Our Ref: 23/1334/TTCA  
Your Ref: Tollit (1 of 2)

**South Cambridgeshire District Council**  
**Application for Works to Trees in a Conservation Area**

Proposal: T1 - Sycamore: reduce height by 3ms and laterals by 2ms to rebalance. Thin remaining crown by 20%

Site address: Kings Farm Stables High Street Horningsea Cambridgeshire

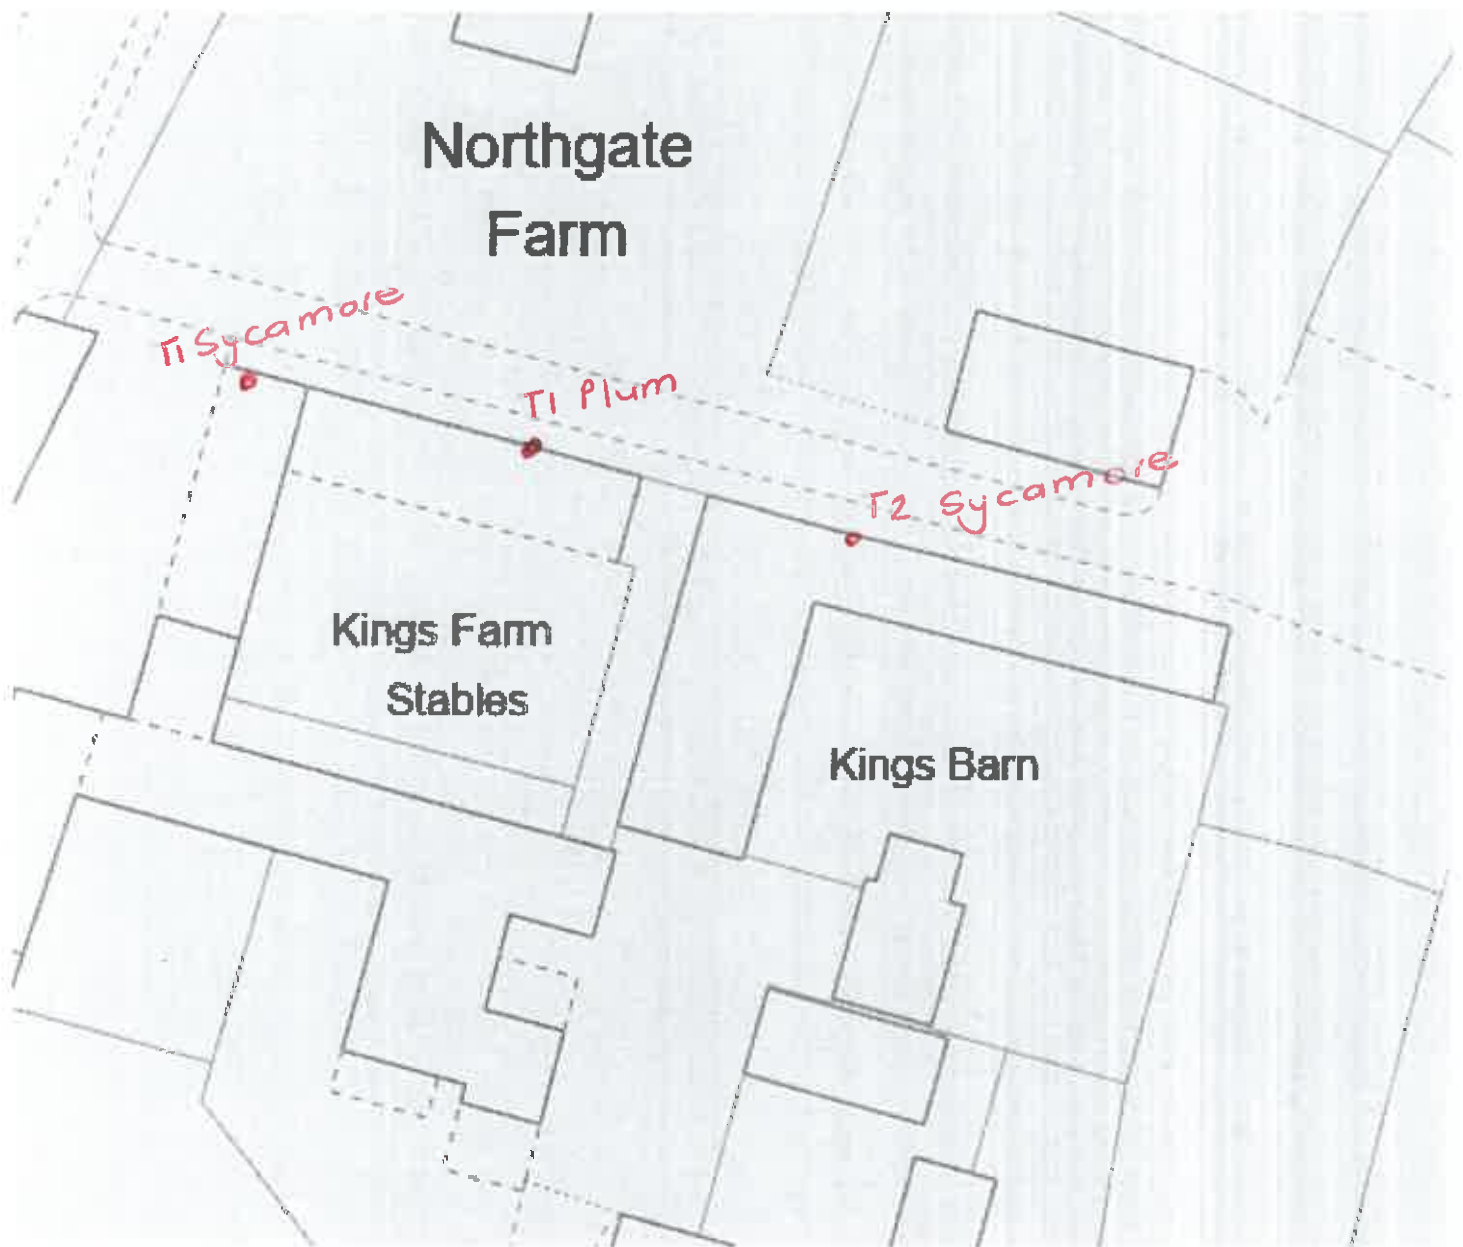
0. The tree location plan does not match a map of the location. The location plans shows T1, T2 and T3 yet the proposal states T1 twice and information states that the plum is owned by a neighbour but details are not provided on the application. Please clarify application/applicant as not clear.
